Application for a Non-Material Amendment Following a Grant of Planning Permission

Add first floor to listed barn serving as garage and workshop, in order to provide bedrooms and games room/gym ancillary to the main house. Relocate existing pool and garden room/plant room. New car port (AMENDED PLANS)

20/00116/LIS and 20/00115/HOU

Alter the pitch of the car port roofs

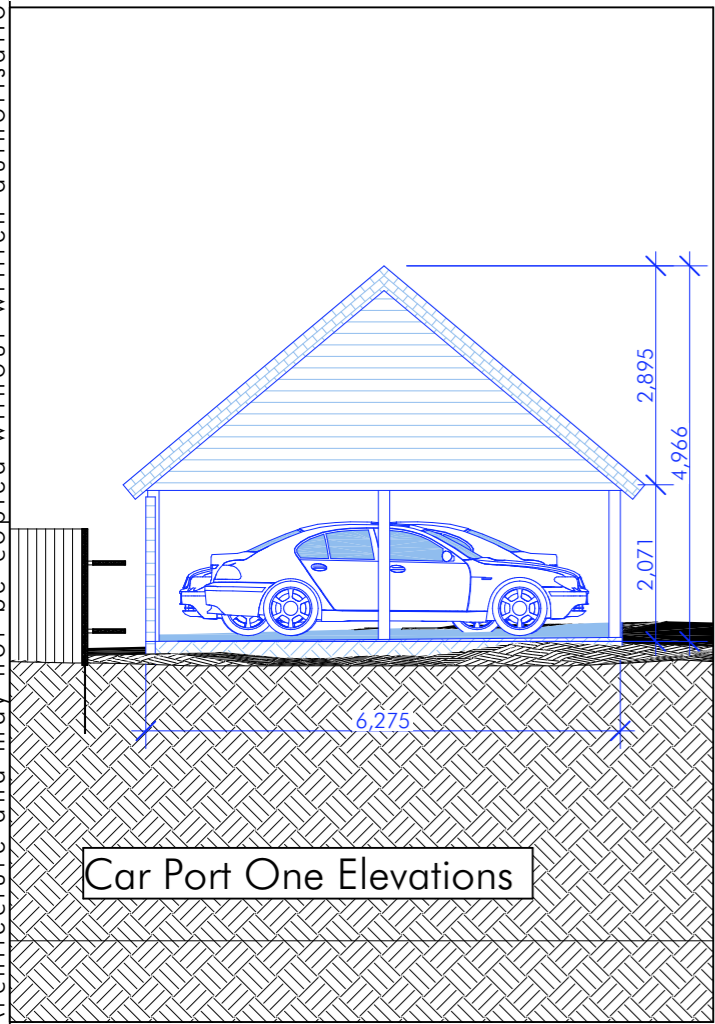
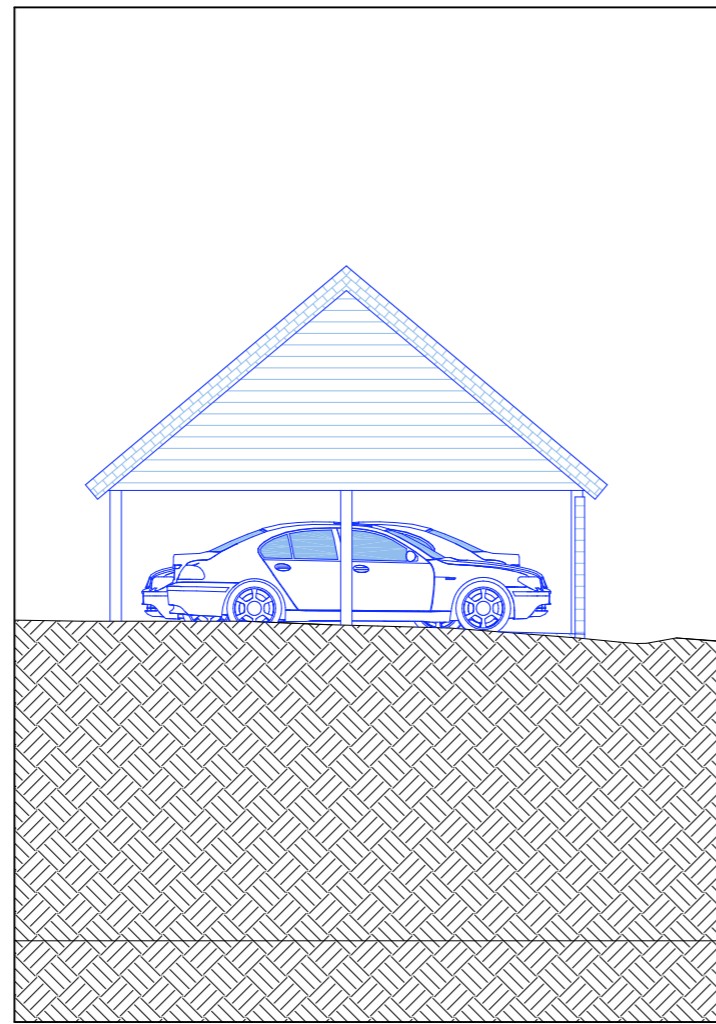
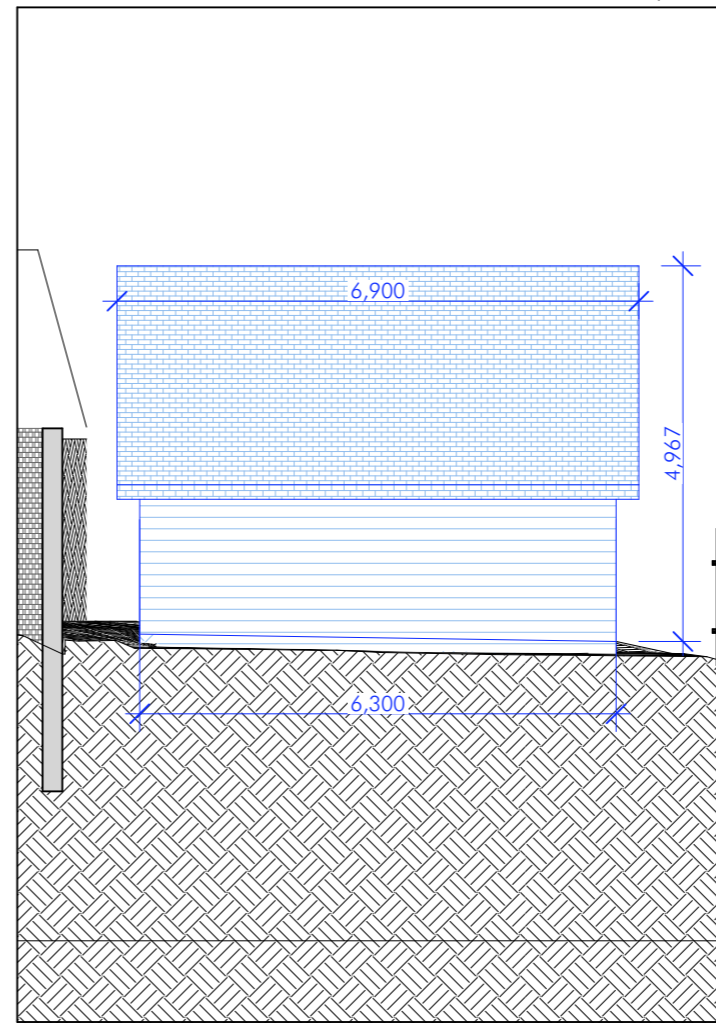
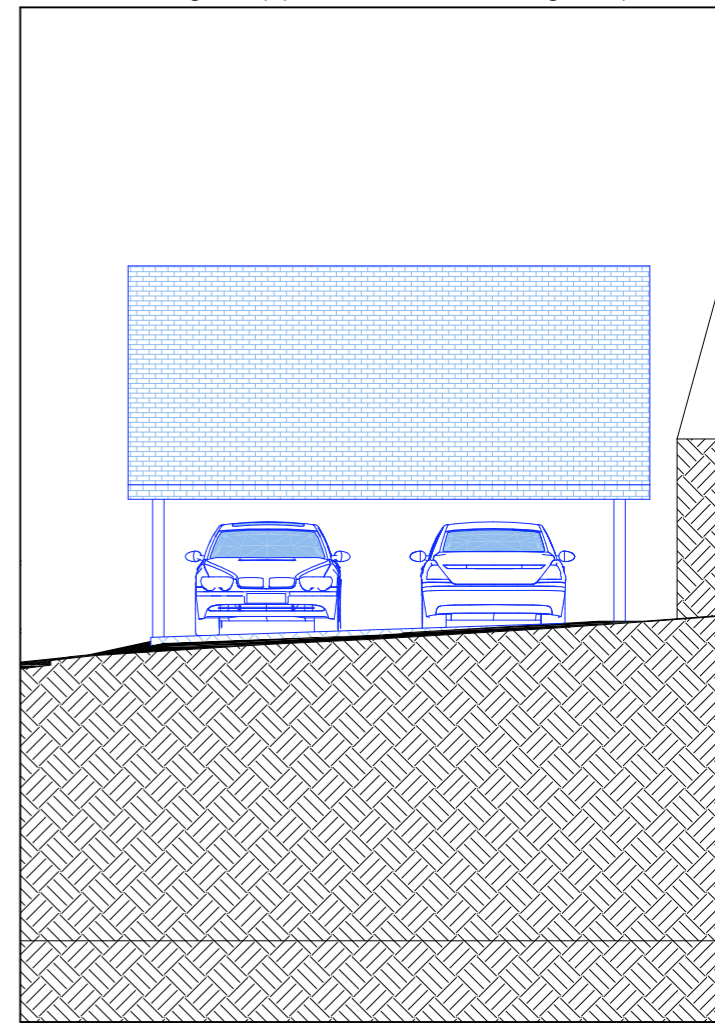
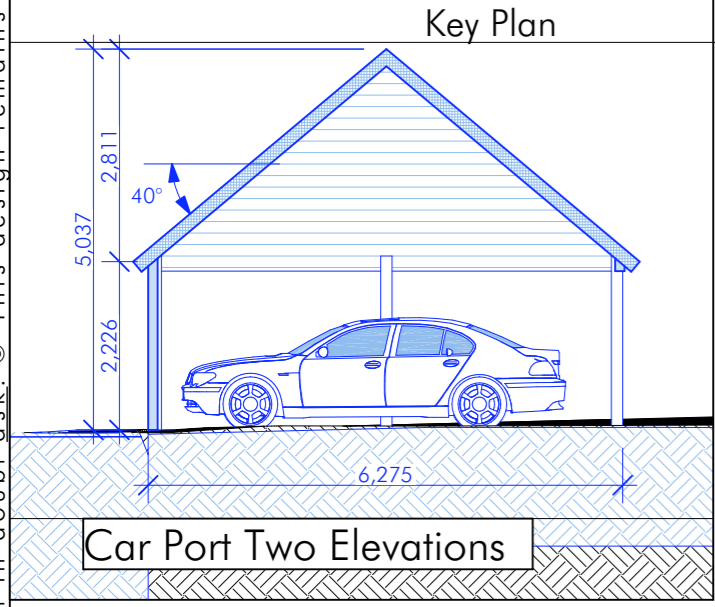
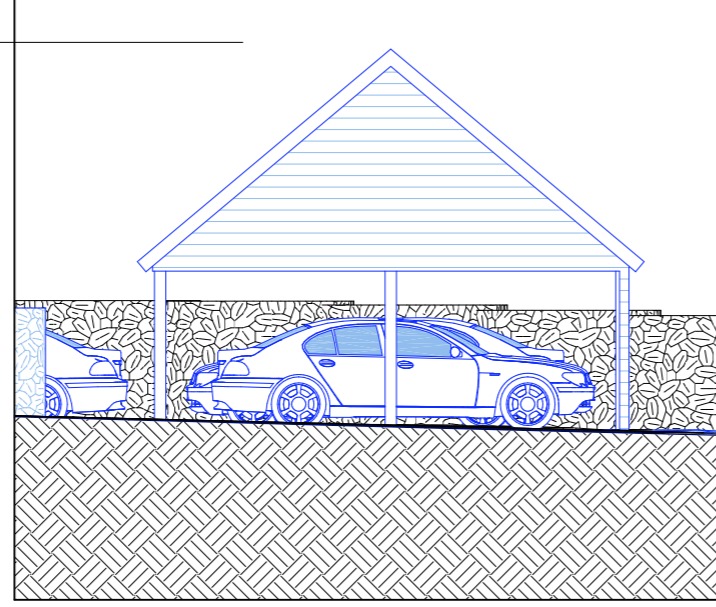
The tile type agreed with the Conservation officer (Keymer handmade plain clay tiles) is not suitable for the approved pitch of roof.

PL19B Existing and Proposed Carport Elevations
